Letter No. C4/2597/2005

Dated: 21-4-2005

Sub: CMDA - Planning Permission - Proposed additional construction of High School building at S.No. 236 of Zamin Royapettah village - particulars - called for - Reg

Site-Plan

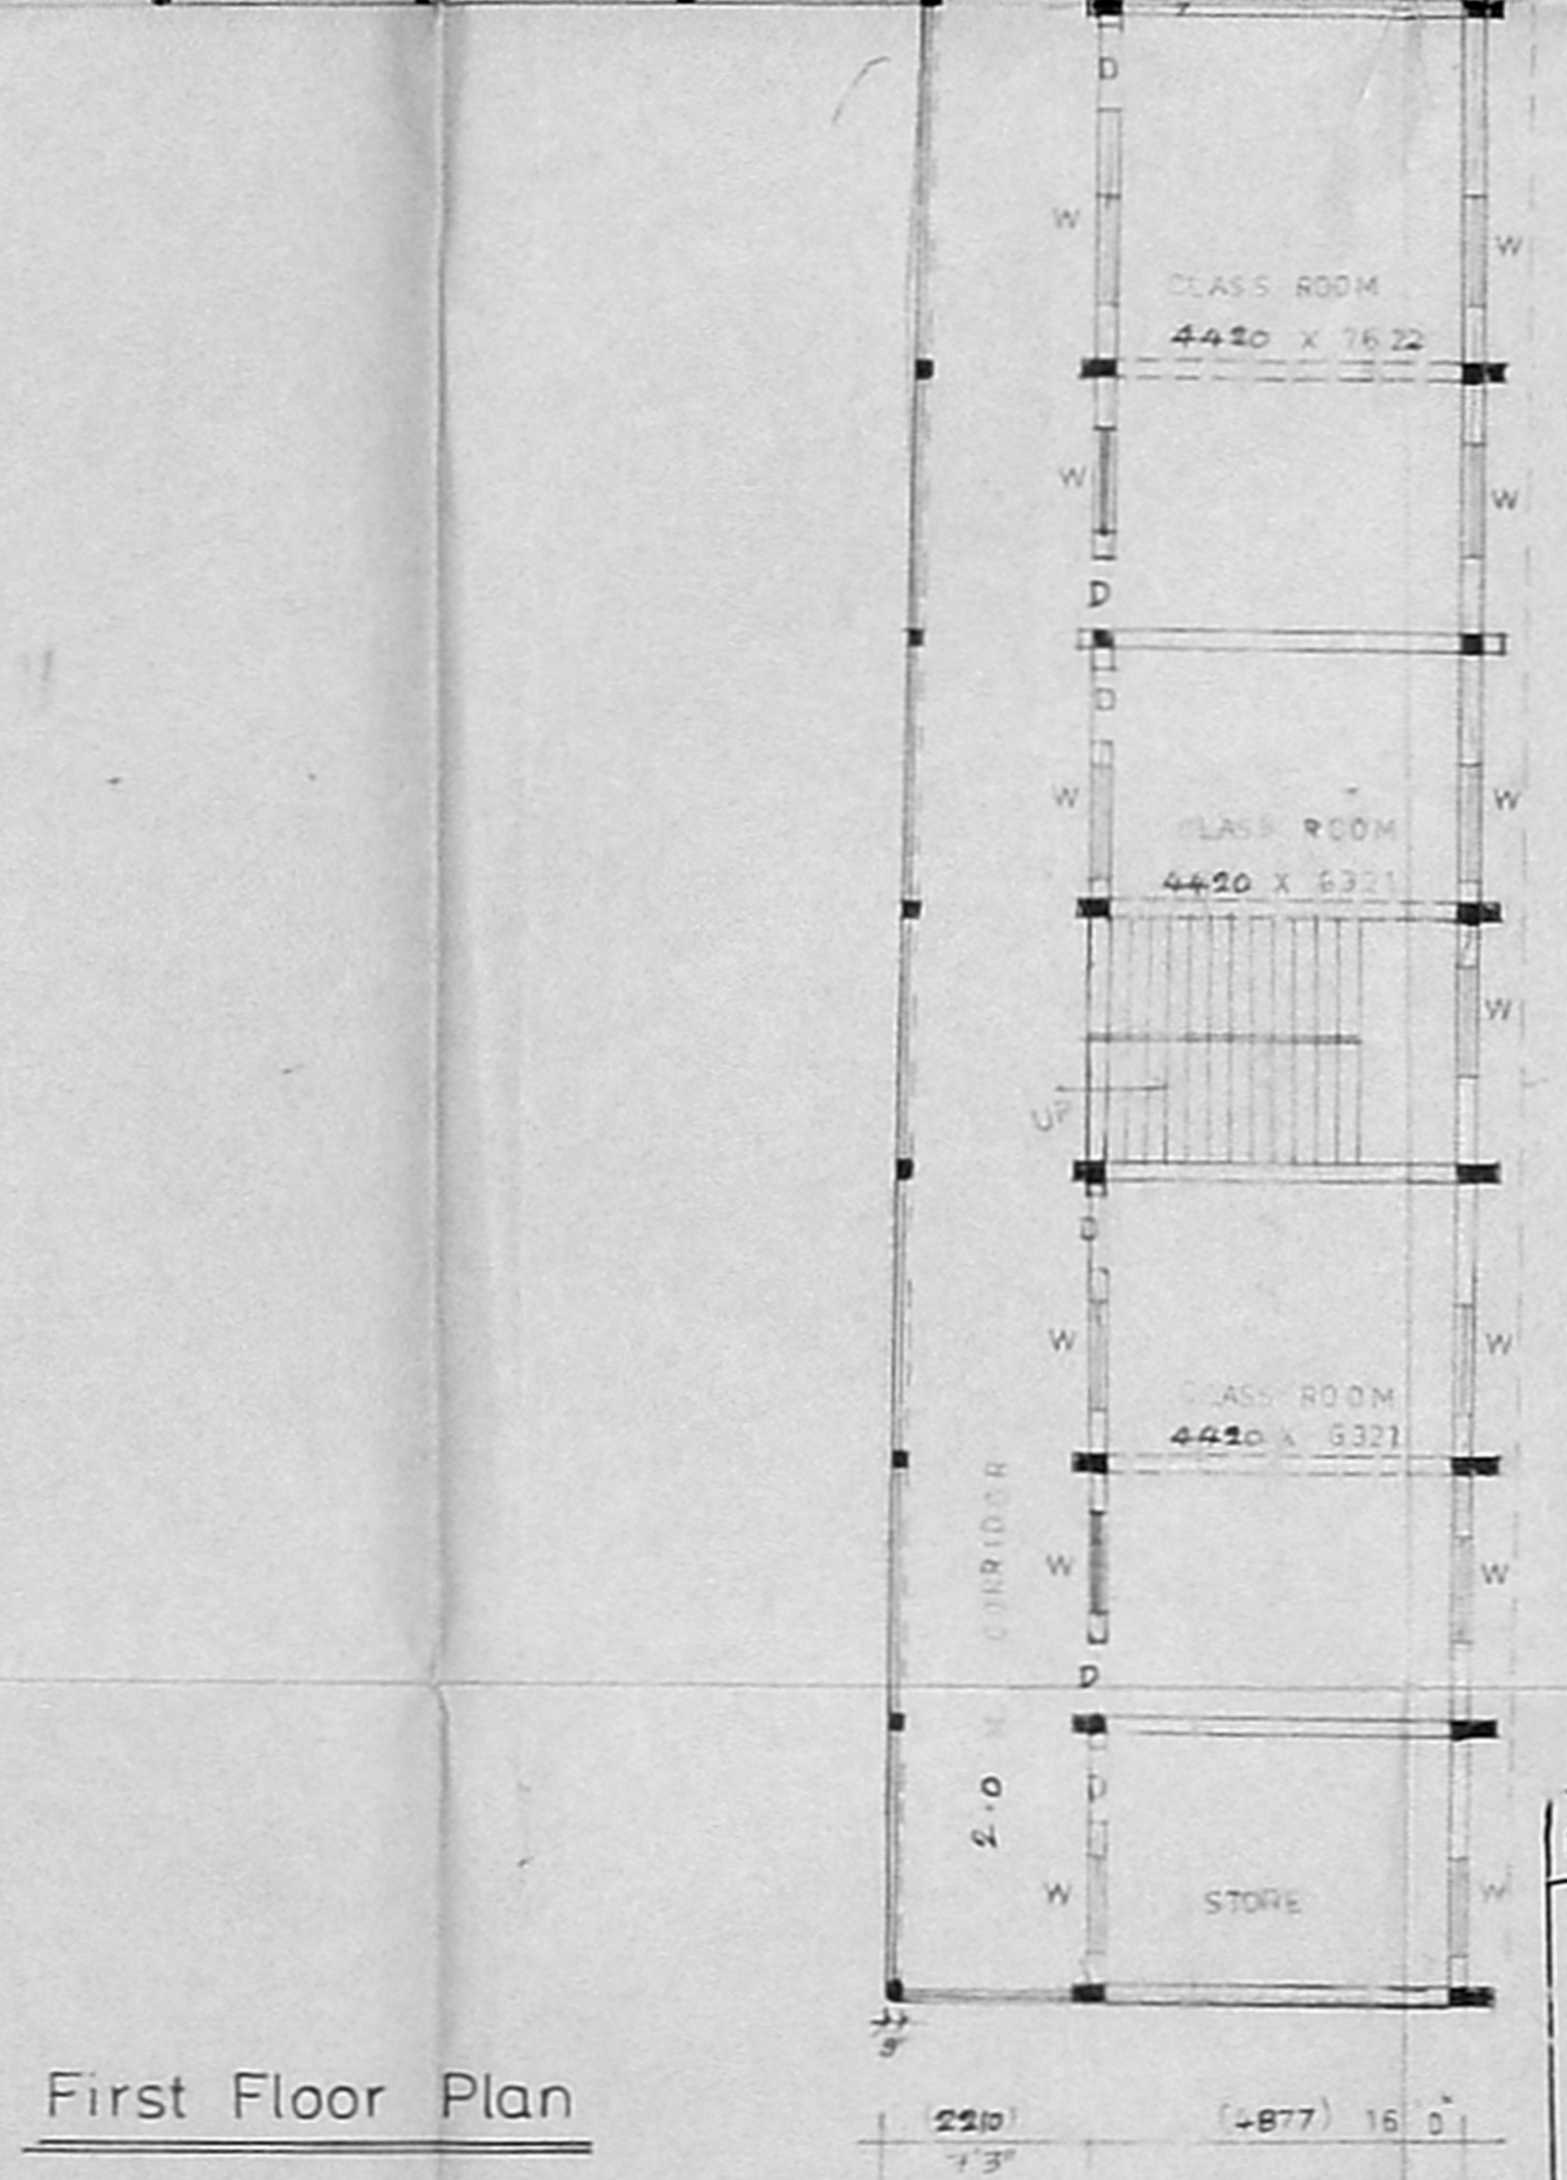
- (1) Proposal violates FSB, RSB, SSB, corridor width, height of the basement and splay.
- (2) Plan does not reflect the site condition with reference to size of the building and structures. Setbacks shall be shown for all the structures at crucial points.
- (3) Required car parking arrangement has not been shown in the site plan satisfying DCR.
- (4) Height of the basement shall be ~~Yours faithfully,~~ 0.90m for the proposal.
- (5) Structurewise, floorwise area details for the existing / proposal / to be demolished shall be ~~shown~~ given in the legend.
- (6) Rain water harvesting details and dwarf wall to a height of 7.5cm have not been shown at the ~~plans~~ entry and exit gates.
